RESPONSE LETTER TO PLAT RE-SUBMITTAL

KITITAS COUNTY **DEPARTMENT OF PUBLIC WORKS**

MEMORANDUM

SUBJECT: Forest Ridge Final Plat Resubmittal LPF-20-00005

PREPARED FOR FRPP PHASE I, LLC A PORTION OF SECTION 24, TOWNSHIP 20 NORTH, RANGE 15 EAST, W.M.		
KITTITAS COUNTY		WASHINGTON
DWN BY T.S.	DATE 01/2021	JOB NO. 18069
CHKD BY M.K.K./D.L.P.	SCALE N/A	SHEET 1 OF 6

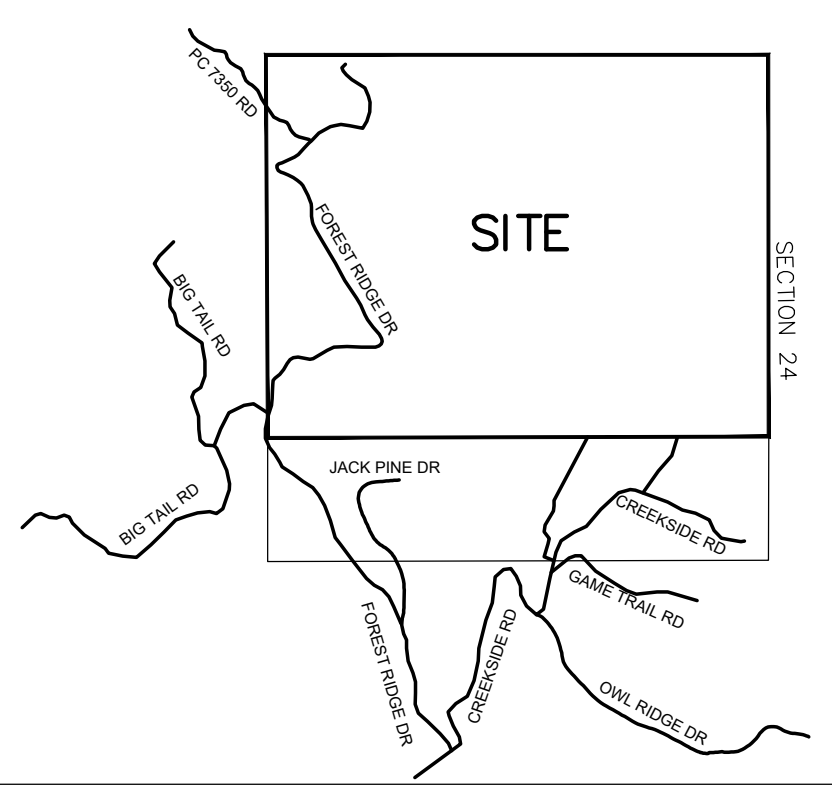
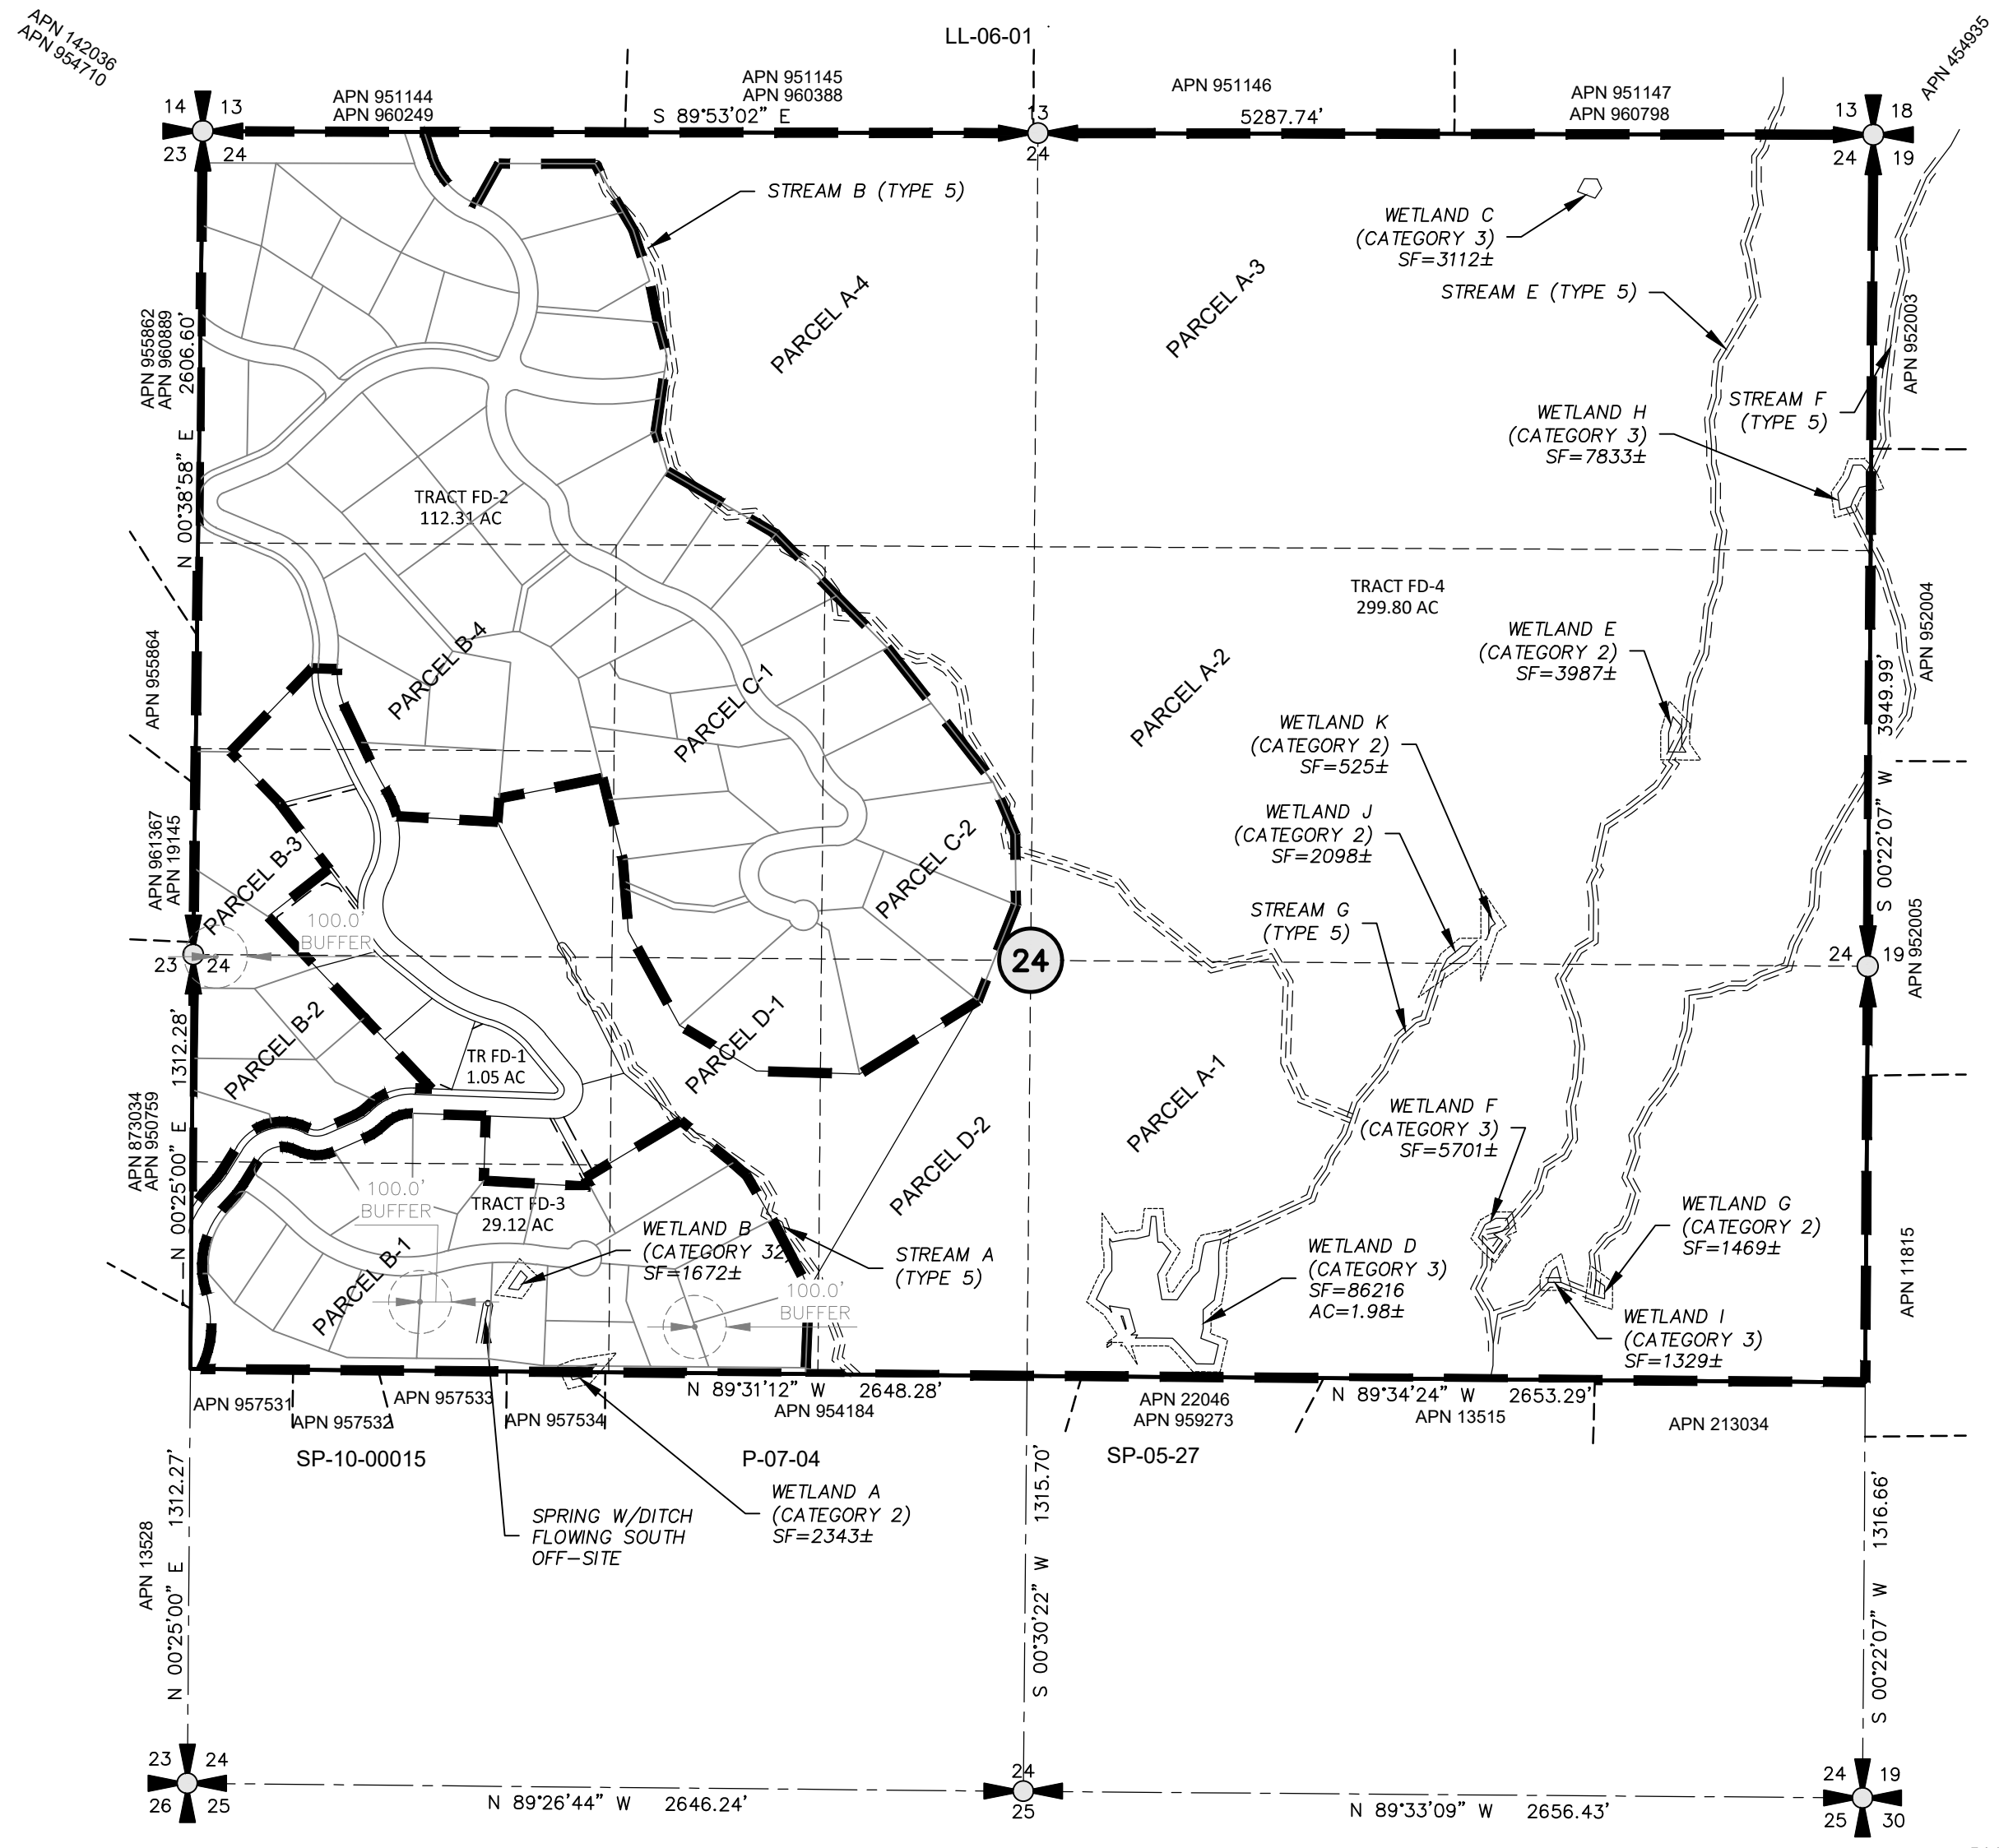
1. Survey Note 3, Sheet 1 shows a blank for the equipment used, and includes a few typos.
2. The N1/4 corner and the E1/4 corner do not have ties to determine the location.
3. Section corners are shown in the legend "as noted". Map contains no such notation.
4. The parcels identified as FD-2, FD-3 and FD-4 do not have any defined limits shown.
5. The historic parcels A-1 through D-2 can be confusing as they are not clearly identified as historic parcels. Including the recording number (AFN or Book and Page) would clarify this.
6. Set corners shall be shown on the face of the plat.
7. References to other pages (See Sheet X of X) are incorrect in the total page count, (all occurrences) as well as the reference page (n[']most label, sheet 5)
8. There are multiple occurrences of labels being obscured by crossing linework.

SEE REVISED PLAT MAPS AND CLOSURES FOR ALL CHANGES REQUESTED BELOW.

FOREST RIDGE - PHASE I PERFORMANCE BASED CLUSTER PLAT		
PREPARED FOR FRPP PHASE I, LLC A PORTION OF SECTION 24, TOWNSHIP 20 NORTH, RANGE 15 EAST, W.M.		
KITITAS COUNTY		WASHINGTON
DWN BY	DATE	JOB NO.
T.S.	01/2021	18069
CHKD BY	SCALE	SHEET
M.K.K./D.L.P.	1" = 500'	2 OF 6

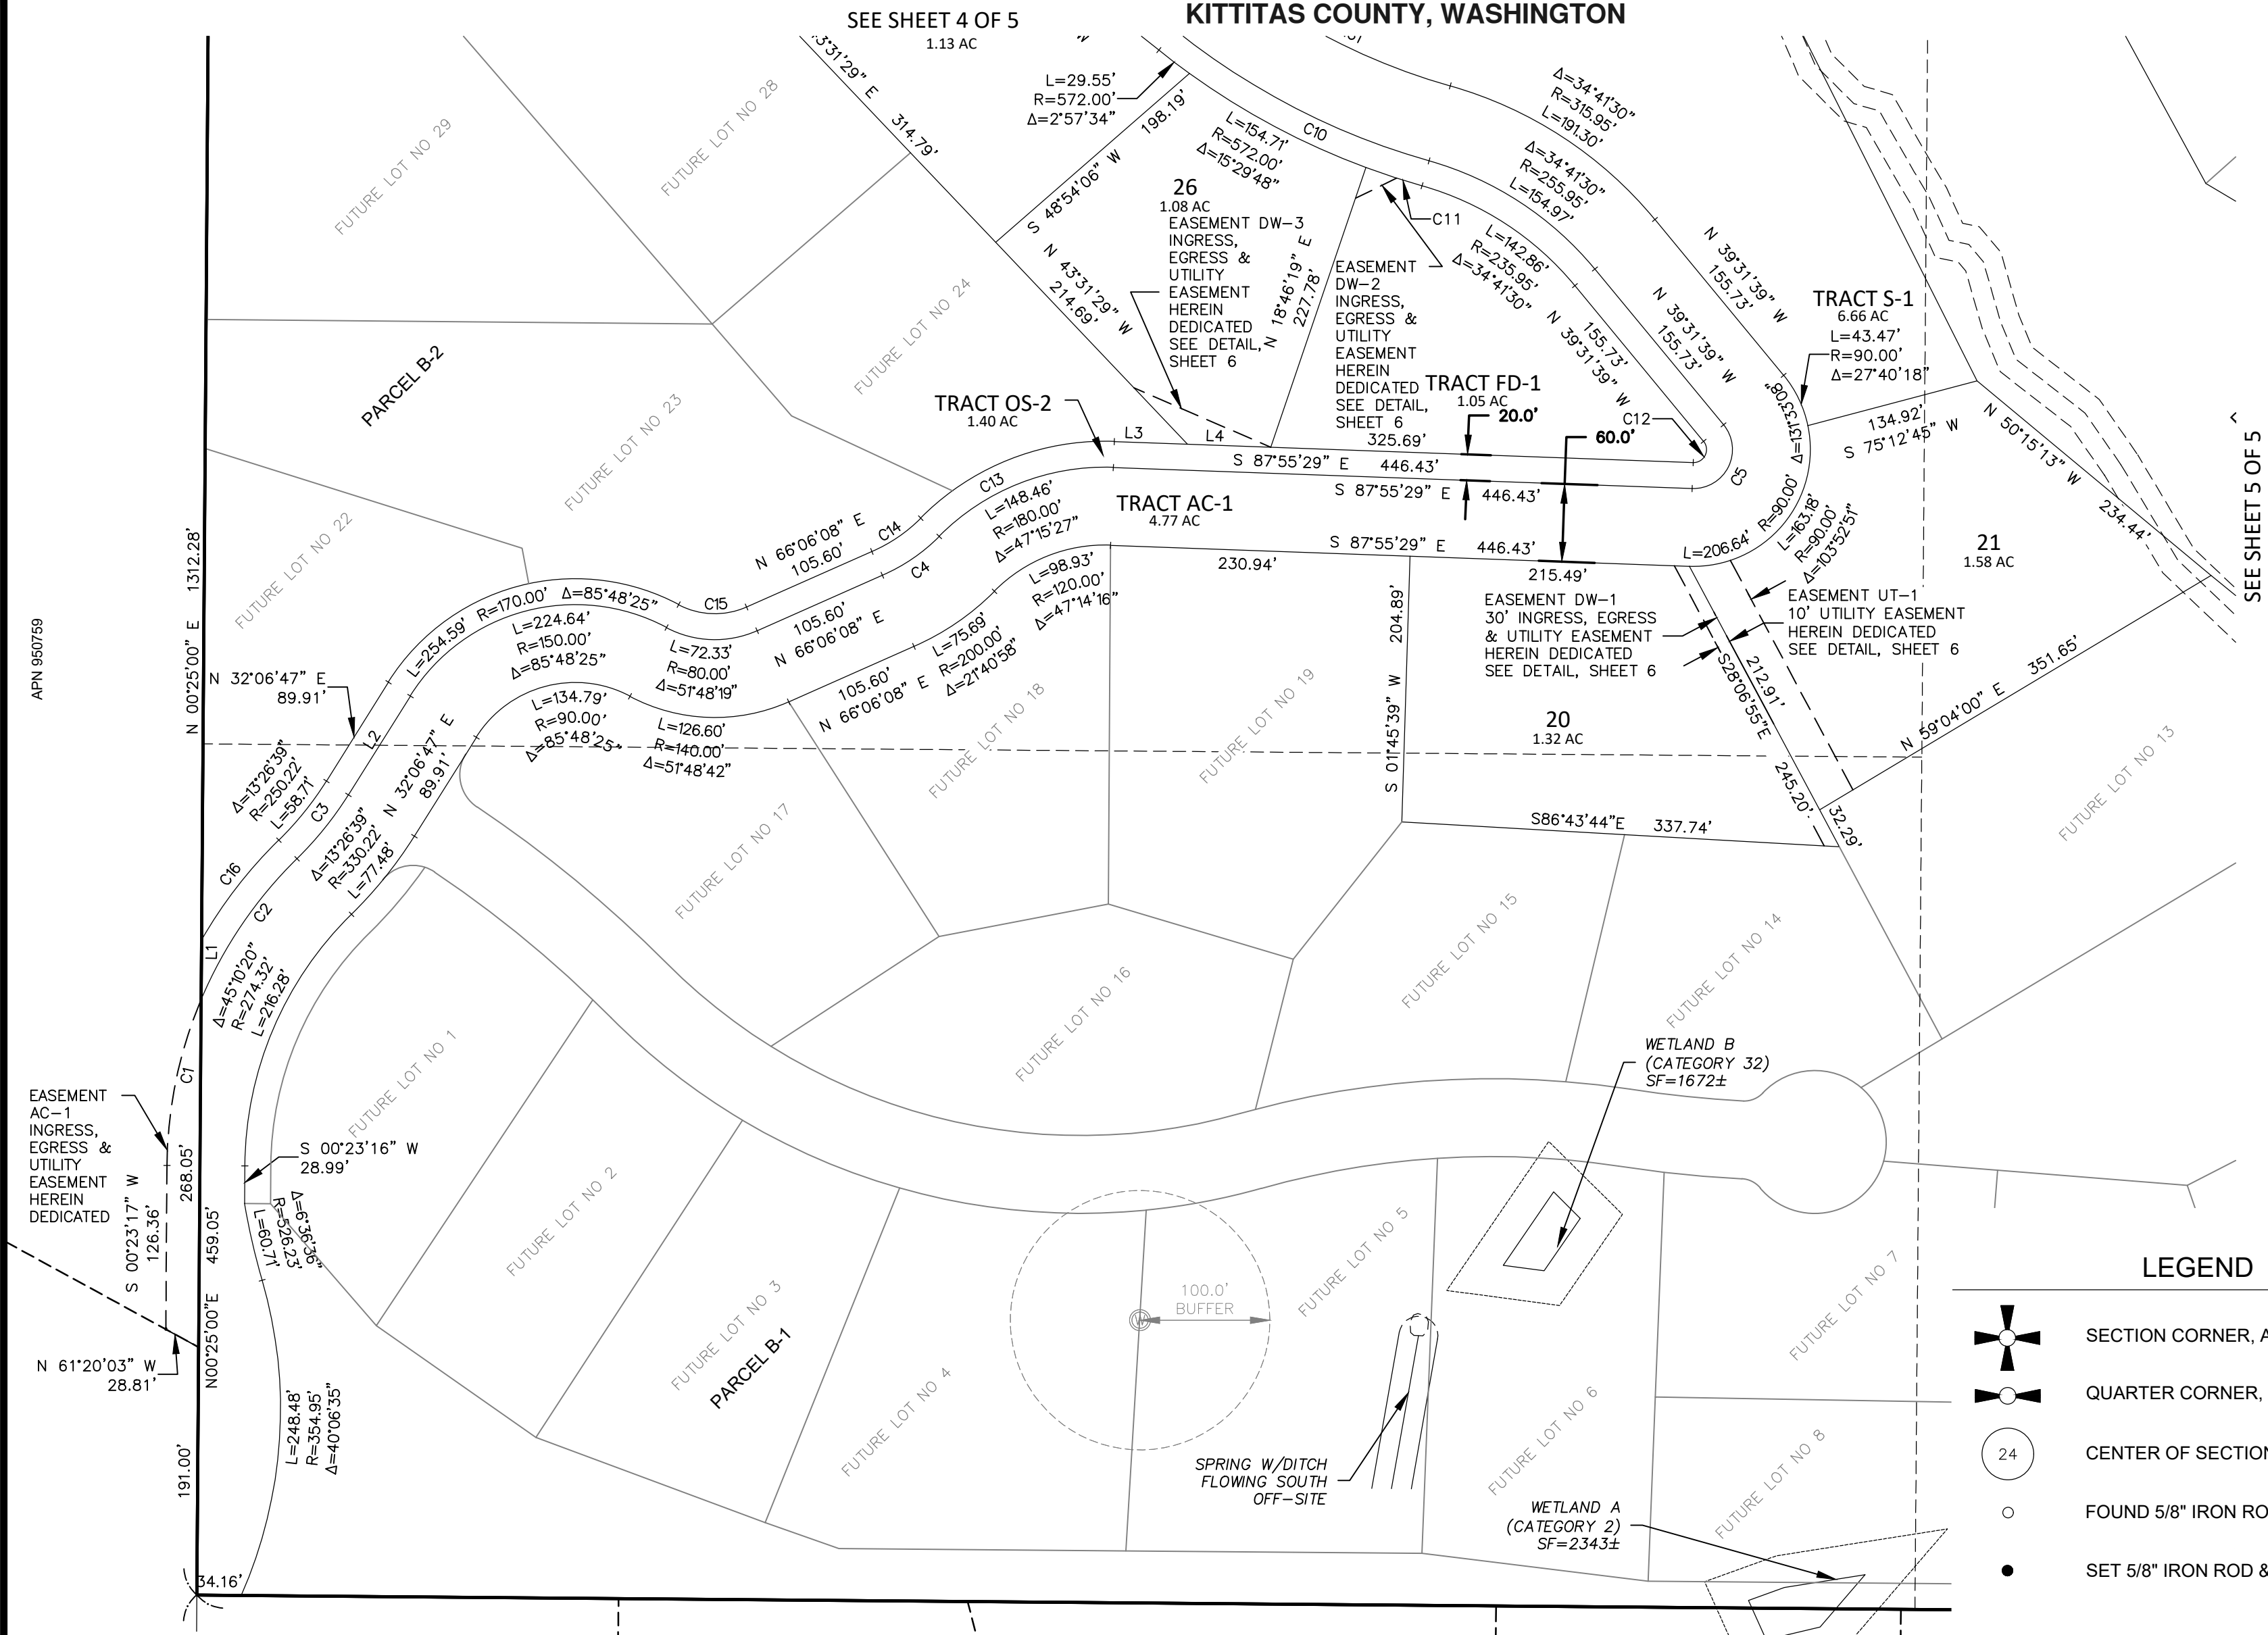
3. Easement AC-1 appears to be outside of the plat boundary. This easement is noted to be herein dedicated by this plat. A plat cannot dedicate an easement that is outside the plat boundary. **THIS EASEMENT AREA HAS BEEN CLARIFIED ON PLAT MAP.**

9. Easement AC-1 cannot be "herein dedicated" as it falls outside of the plat limits. Please include the recording number of the easement, or show it as "to be filed by separate document"

10. If Tract AC-1 is an existing roadway, please include road name, surfacing, and ownership (EX: Forest Ridge Road, Private R/W- Gravel)
11. The South Boundary of AC-1, near Lot 26 has a missing label.
